HKTA / a r c h i t e c t s

October 1, 2013

About: 133 York Street; Meeting with Planning Staff, Sept. 23 @ 1:00 PM

1 FIRST FLOOR PLAN
A-101 Scale: 1/4" = 1'-0"

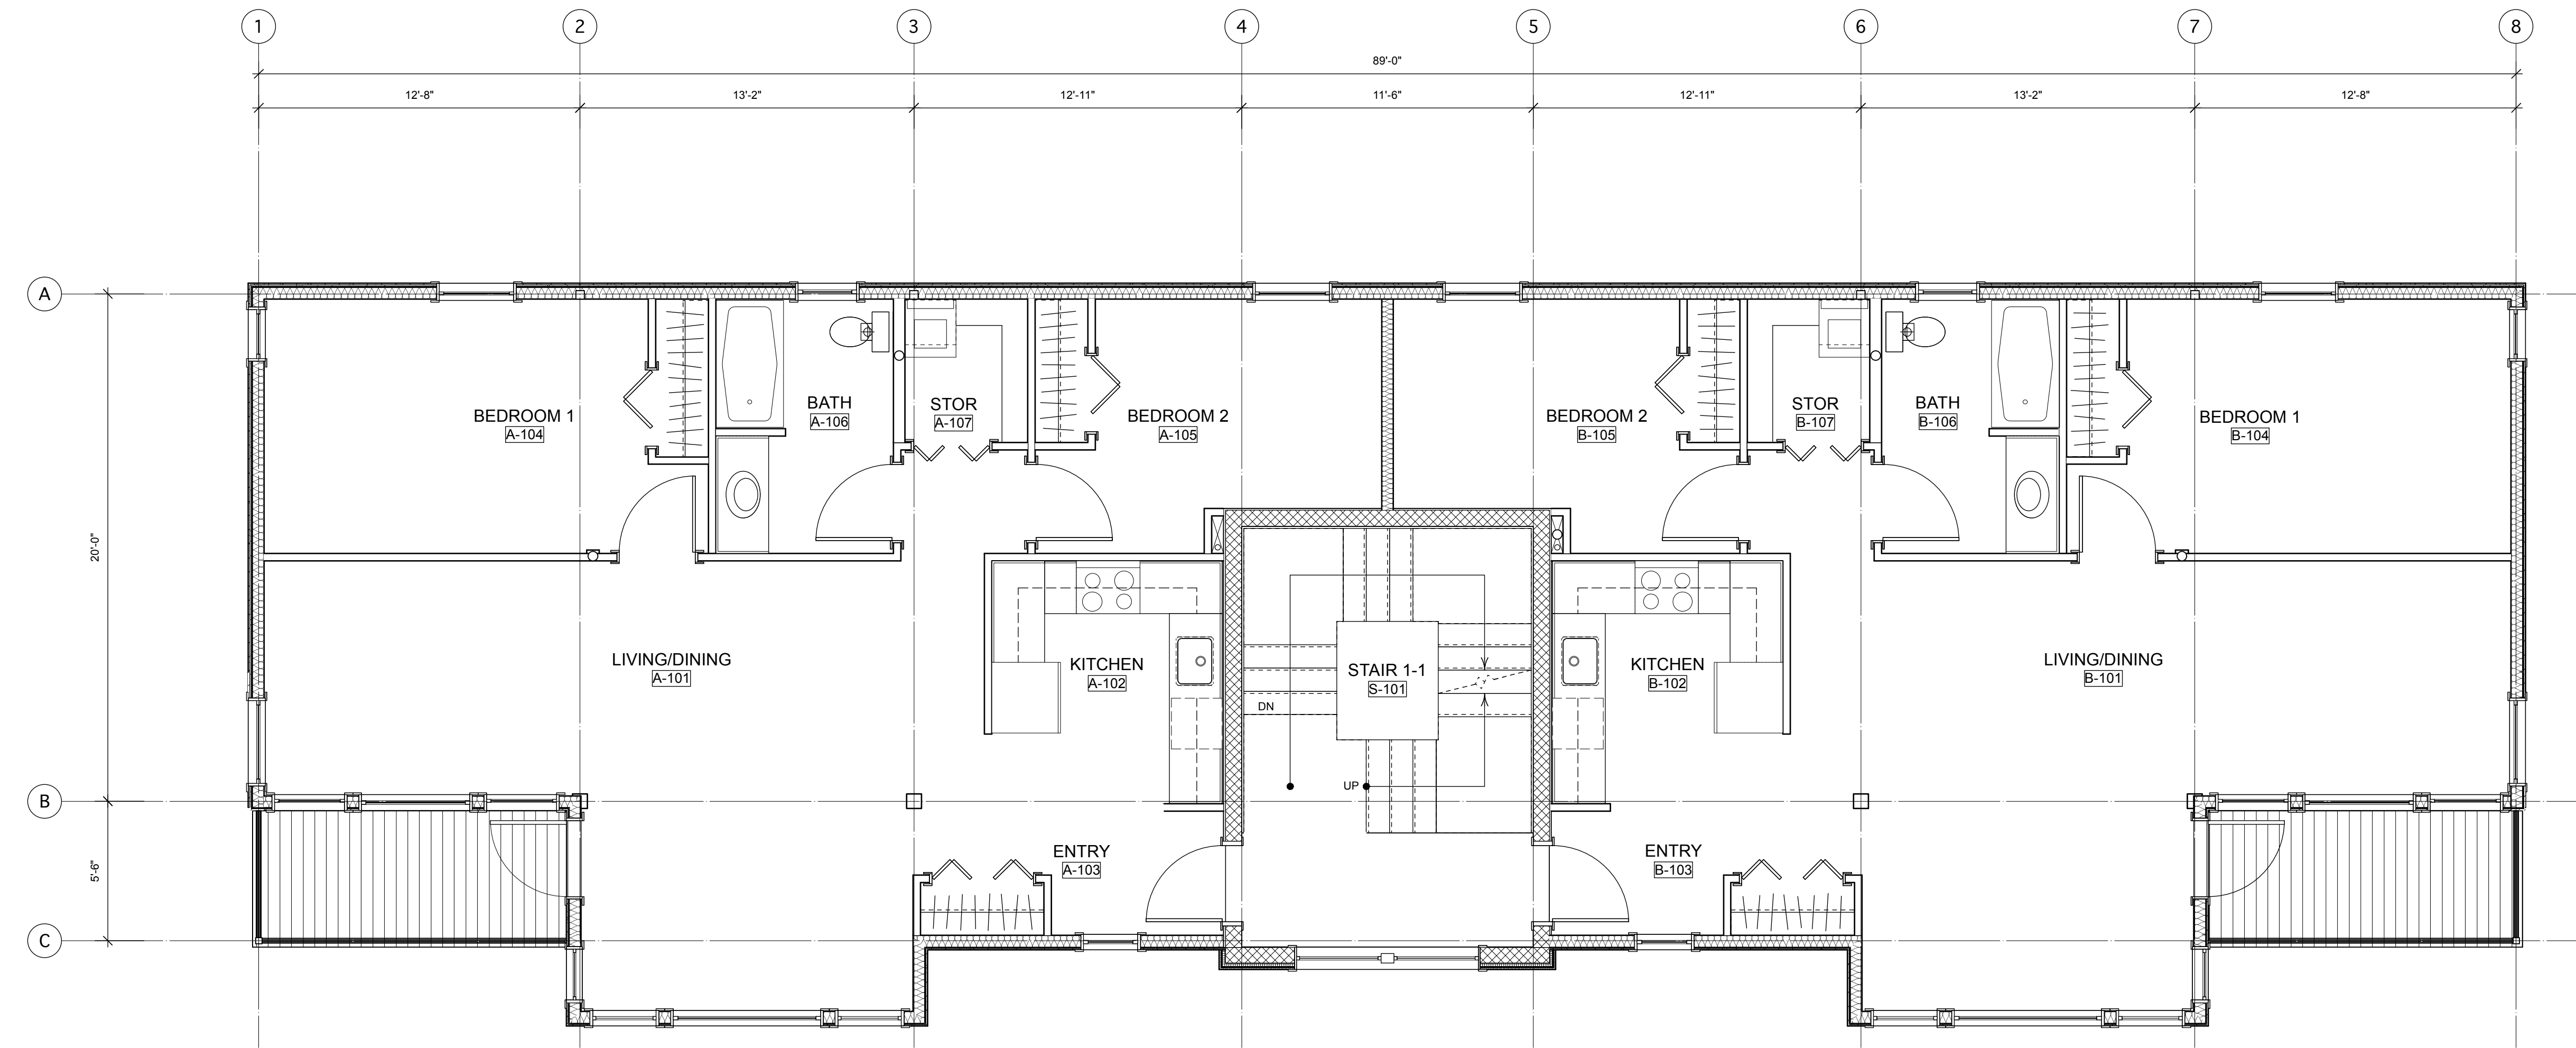
We were encouraged to create a more open entrance. A wider entrance and one with more glass to create an airiness feel to the lobby was seen as desirable and in keeping with Design Principles. While the entrance and stairwell to the owner units are already well light by natural light from windows on each floor, which will flood the stairwell with light, a more generous entrance assembly was considered necessary at the first floor. (Final submittal provides a larger opening on the first floor).

1
A-202
NORTH ELEVATION
SCALE: 1/4"=1'-0"

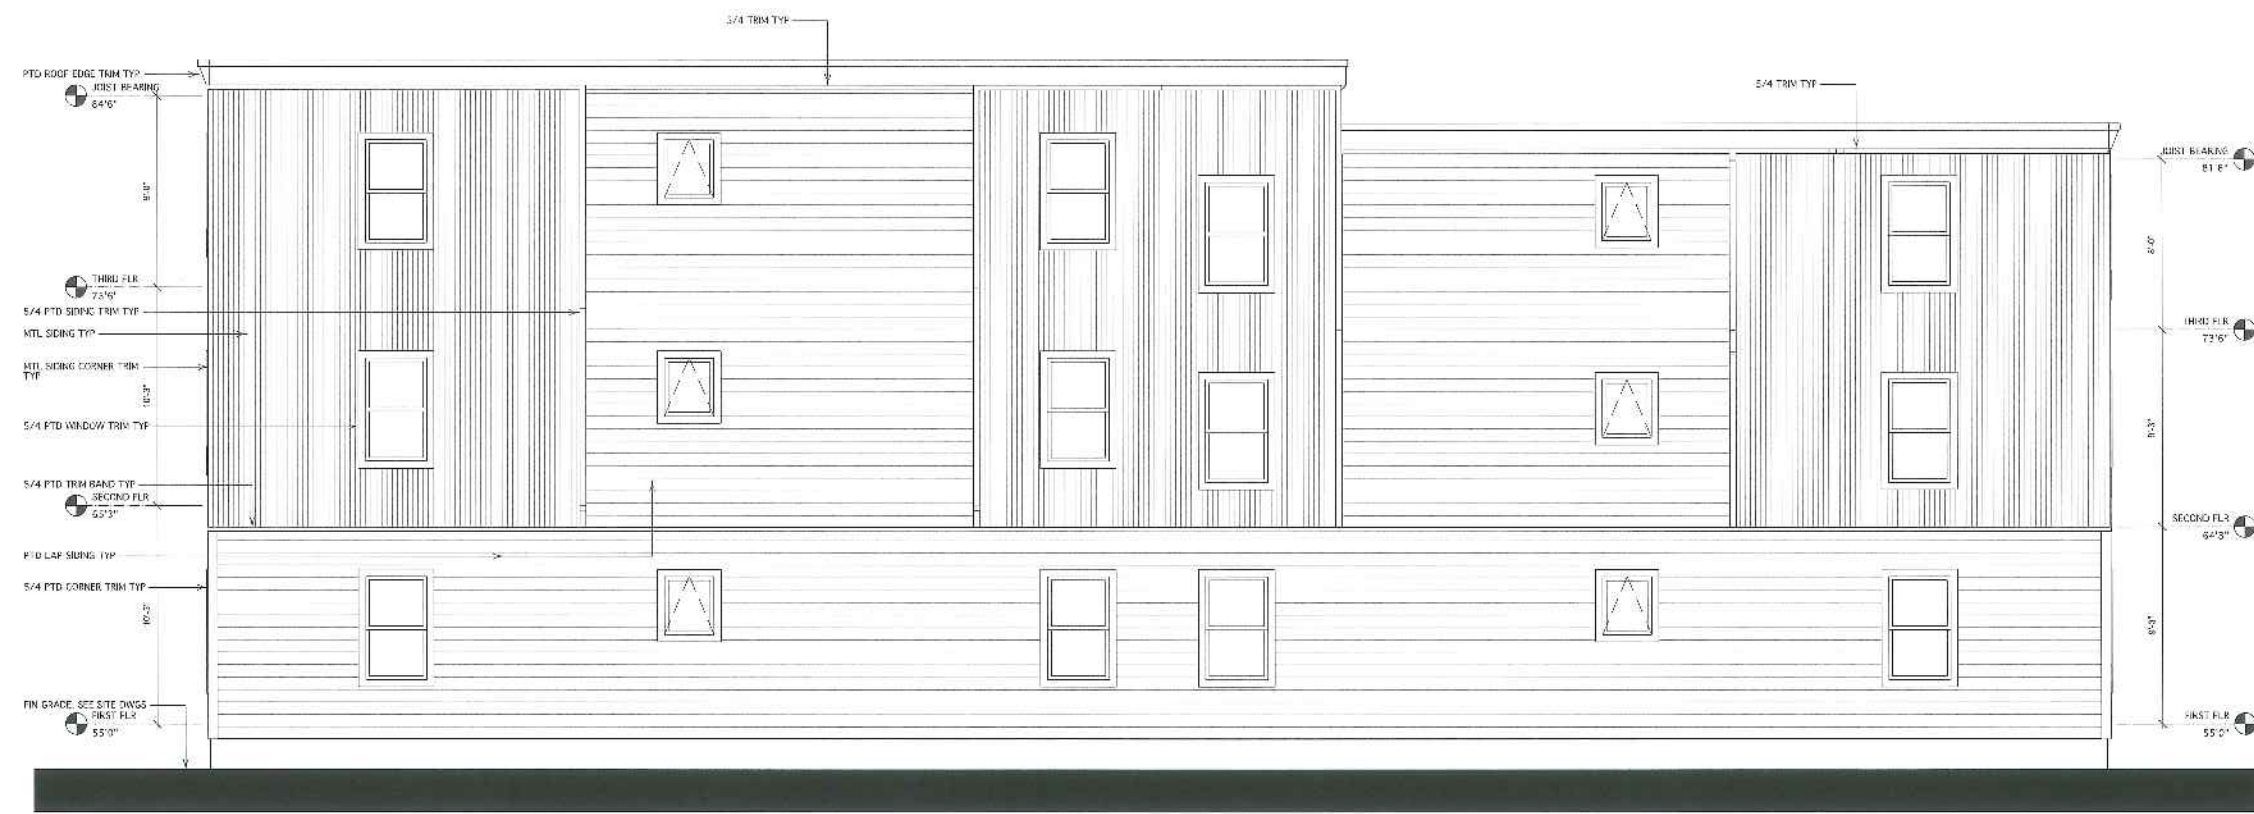
Discussed back-side elevation and were encouraged to create a more neighborly face and to develop more expression of planes on the back. (The final submittal makes the for a subdivision of the façade into four components each reflective of the interior function and then using the trim elements in the paragraph above to articulate these by using the trim to provide texture and composition).

Review the color scheme and material. We presented actual samples of the siding. (Final submittal illustrates the revised siding assembly on back-side. Important to note that there is 1 x 4 trim around all openings, Horizontal trim is 1x 8 nominal and vertical trim is 1x6 nominal. Trim is the same color as horizontal siding. The windows in the bay feature on the rear are capped by 1x8 head trim. These features offer texture and articulation to the facades).
